WEST SUSSEX COUNTY COUNCIL CONSULTATION

TO:	Arun District Council FAO: Michael Eastham
FROM:	WSCC - Highways Authority
DATE:	28 May 2021
LOCATION:	L'Apache Westergate Street Woodgate PO20 3SQ
SUBJECT:	AL/50/21/PL Variation following grant of AL/103/18/PL to amend Condition No 2 approved plans - to change the design & layout of approved 2 No. dwellings.
DATE OF SITE VISIT:	n/a
RECOMMENDATION:	Advice
S106 CONTRIBUTION TOTAL:	n/a

This application is for the variation of Condition 2 - approved plans of AL/103/18/PL to change design and layout of the approved 2 dwellings.

Project:-	Proposed Residential Development L' Apache Westergate Street Woodgate Chichester		
Title:-	Block Plan		
Client:-	Randmere Limited		
Scale:-	1:500 (@A3)		
Drawn By:-	PJD	Checked By:-	
Date:-	23/04/21	Date:-	
Job.No:-	210005	Drg.No:-	02

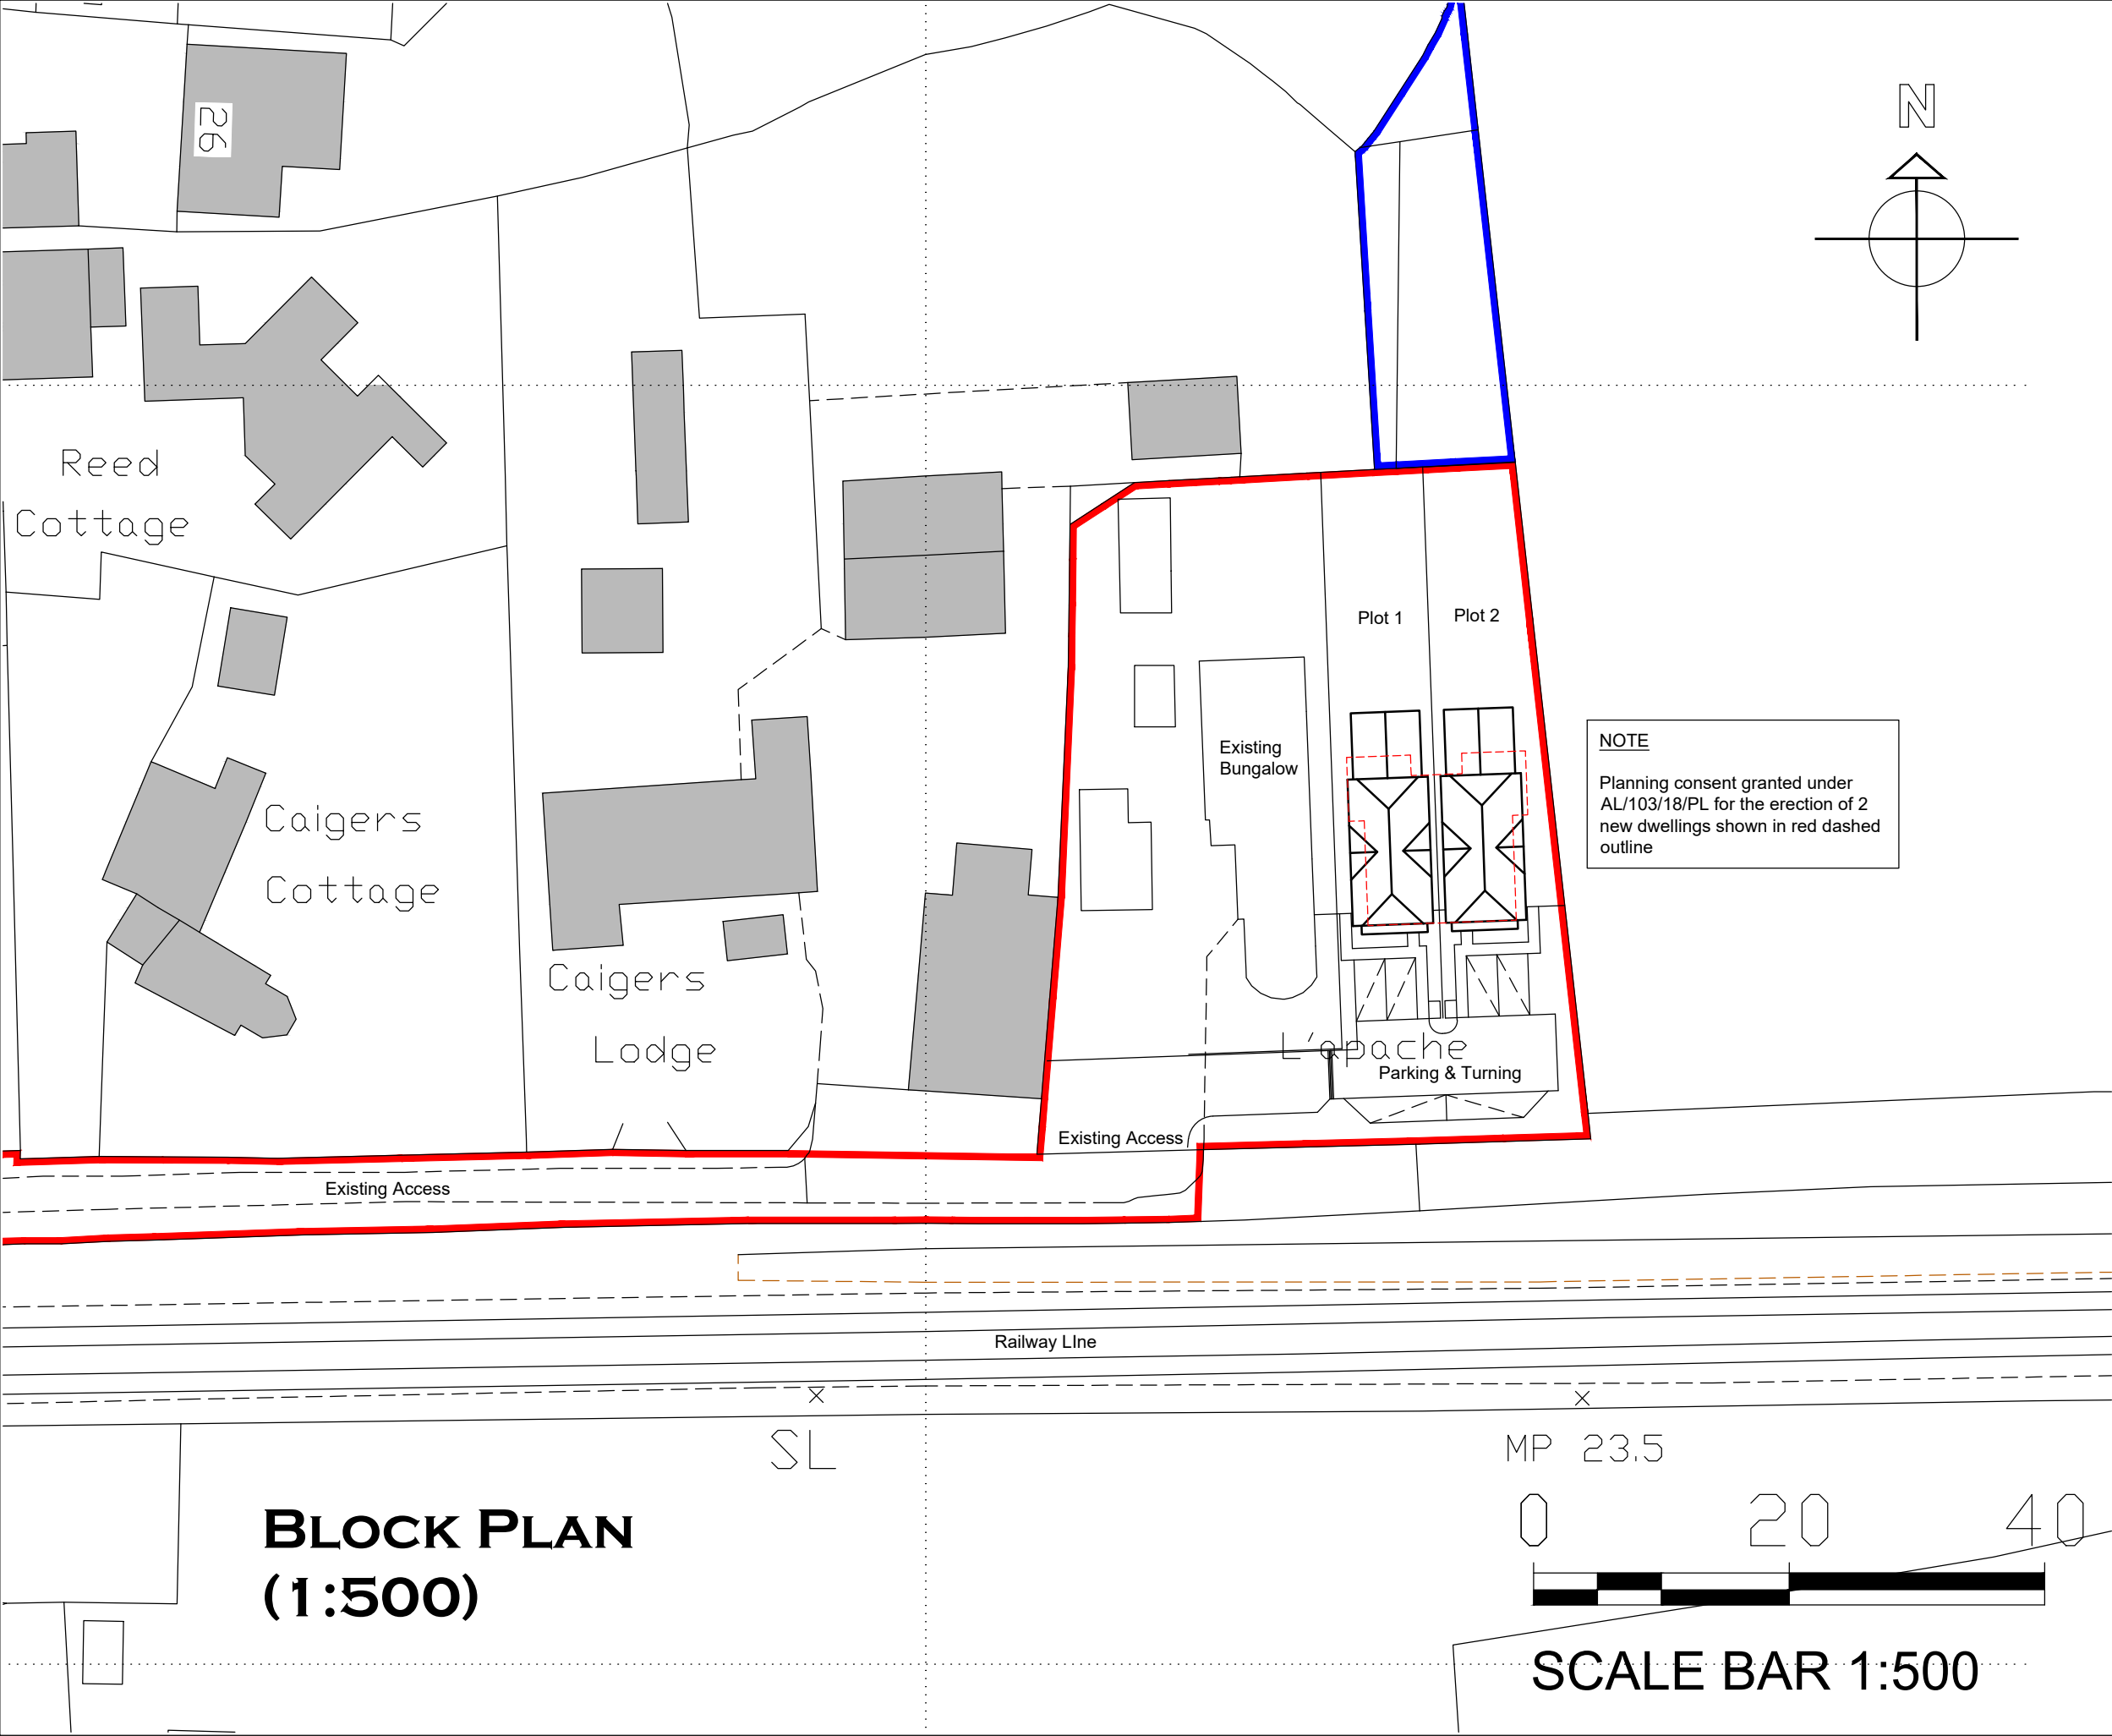
The variation of condition will see both dwellings increased from 3 bedroom dwellings to 4 bedroom dwellings. The WSCC parking demand calculator expects that a minimum of three parking spaces will be required per dwelling in this location. The proposed plans demonstrate that a third parallel parking space has been provided for each dwelling within the previously approved turning area. Sufficient space remains within the turning area for vehicles to turn on site and exit in a forward gear.
